From: Sue Howell
Sent: 08 September 2015 16:48
To: Planning.Responses
Cc: Richard Temple
Subject: RE: Planning Consultation on: BN/29/15/PL

Comment from Greenspace

APPLICATION BN/29/15/PL

Description of Works: Solar park including the erection of solar arrays, inverters, transformers, equipment housing, security fencing, internal tracks, ancillary equipment & ecological mitigation. This is a Departure from the Development Plan.

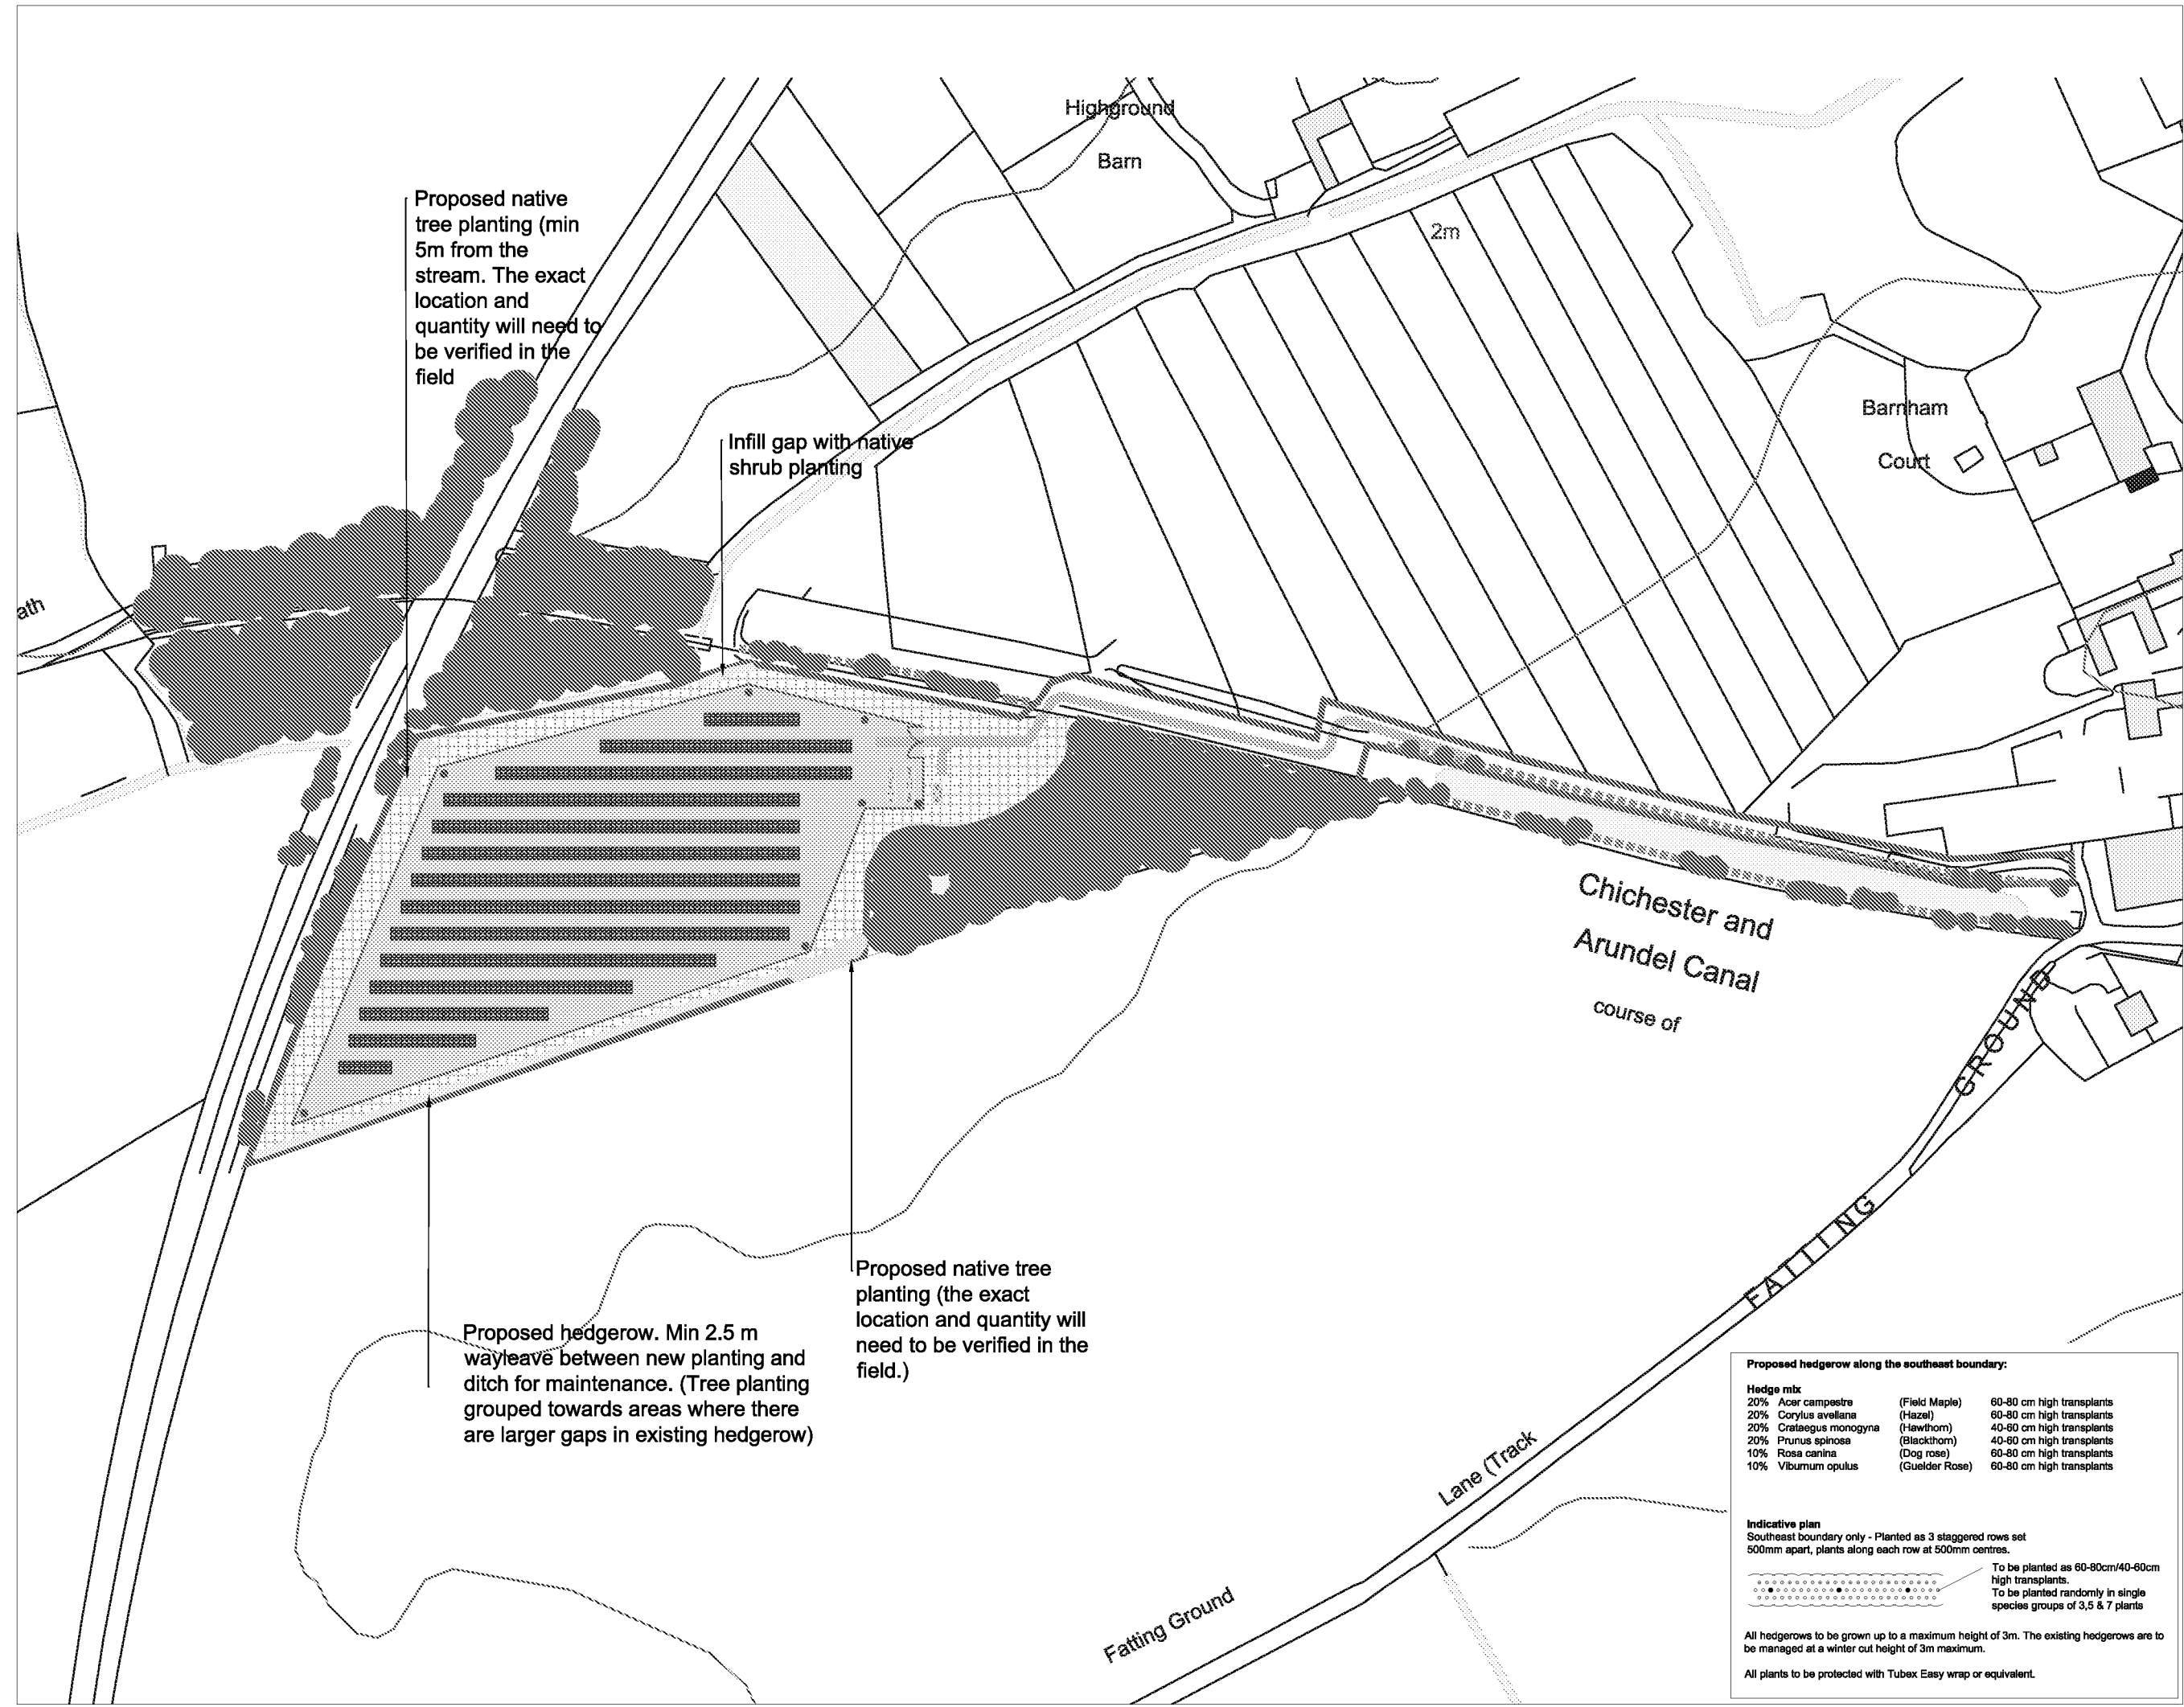
Landscape drawing 27766-200-MITIGATION PLAN Rev A details areas to be planted and areas to be infilled. However this plan is only indicative and needs to show this information plotted on the drawing with actual planting quantities so that the full picture can be seen. We would recommend that further landscape detail is submitted for approval.

We conclude that we have no objection to the proposals subject to the plotting of new planted areas in detail and in plan form.
